**Lindfield Learning Village Phase
2 and 3**

Traffic and Transport Assessment
Response to Submissions

Issue | 11 September 2019

LOCATION PLAN & CONSTRUCTION VEHICLE ROUTES

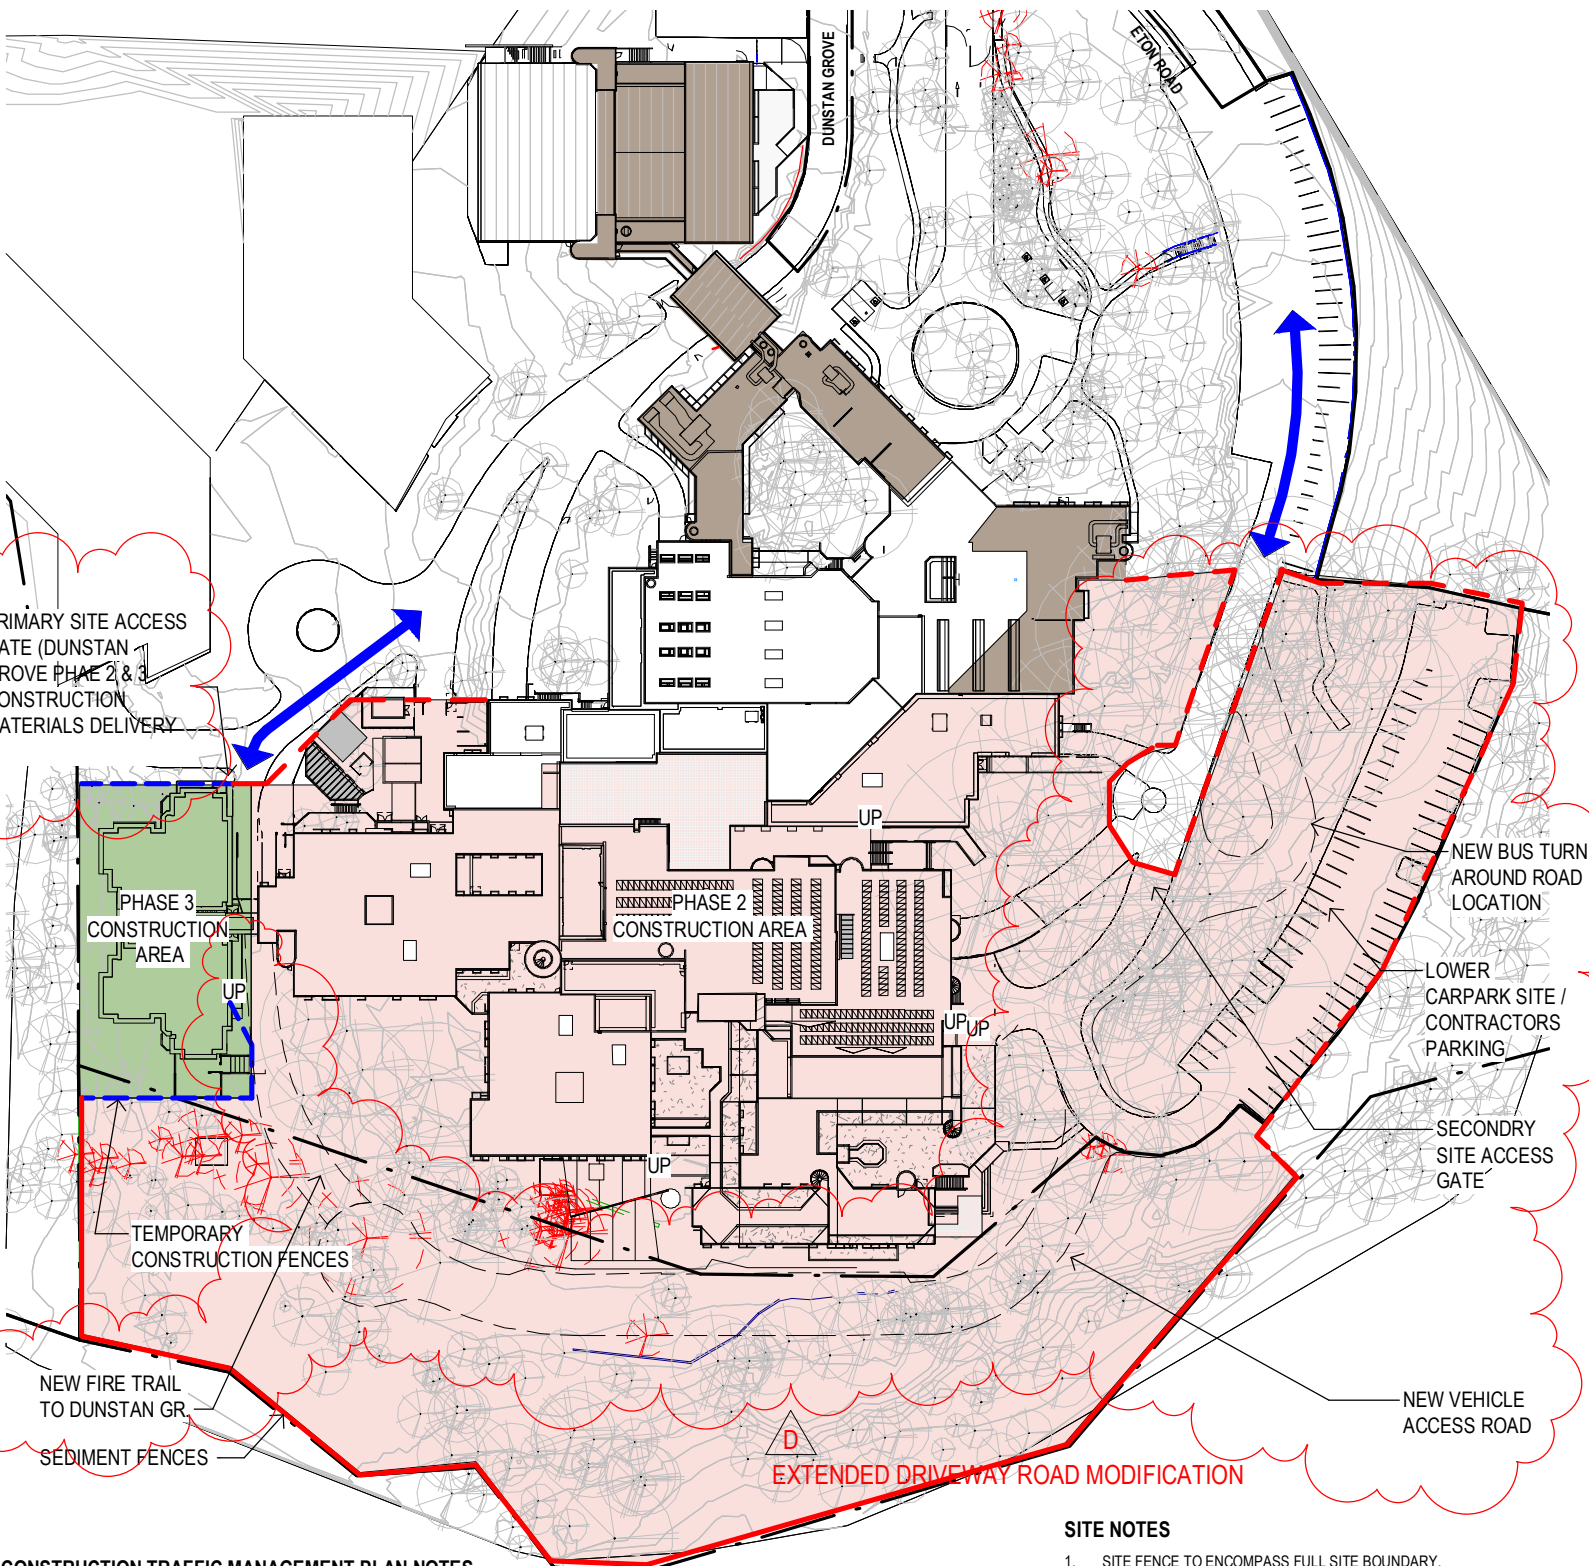
R#	Comment	Arup response
		As such the learning village should not be required to provide upgrades or contribute to them.
R38	[4.6] The construction traffic vehicle routes shown in Figure 53 suggest Lady Game Drive would be an access route from the south-west. It should be noted that Lady Game Drive is a load limited road and due to its horizontal and vertical alignment is not suited to ongoing construction traffic, especially large rigid trucks and articulated heavy vehicles. Also, heavy construction vehicles travelling on Grosvenor Road may be subject to movement restrictions during School Zone times, to minimise conflicts with drop-offs and pick-ups associated with Lindfield Public School. Further consultation with Ku-ring-gai Council is recommended for the development of the construction routes.	Was incorporated into the Detailed Construction Management Plan.
TTA Supplementary		
R39	Private vehicles - How will pick up operation be achieved.	There is extensive queuing area on the site if parents do choose to come early. We are trying to spread the load by asking parents to arrive after the finish time so that students are ready to be picked up. A system of matching students to cars is being utilised to assist with efficient operations at pick-up time.
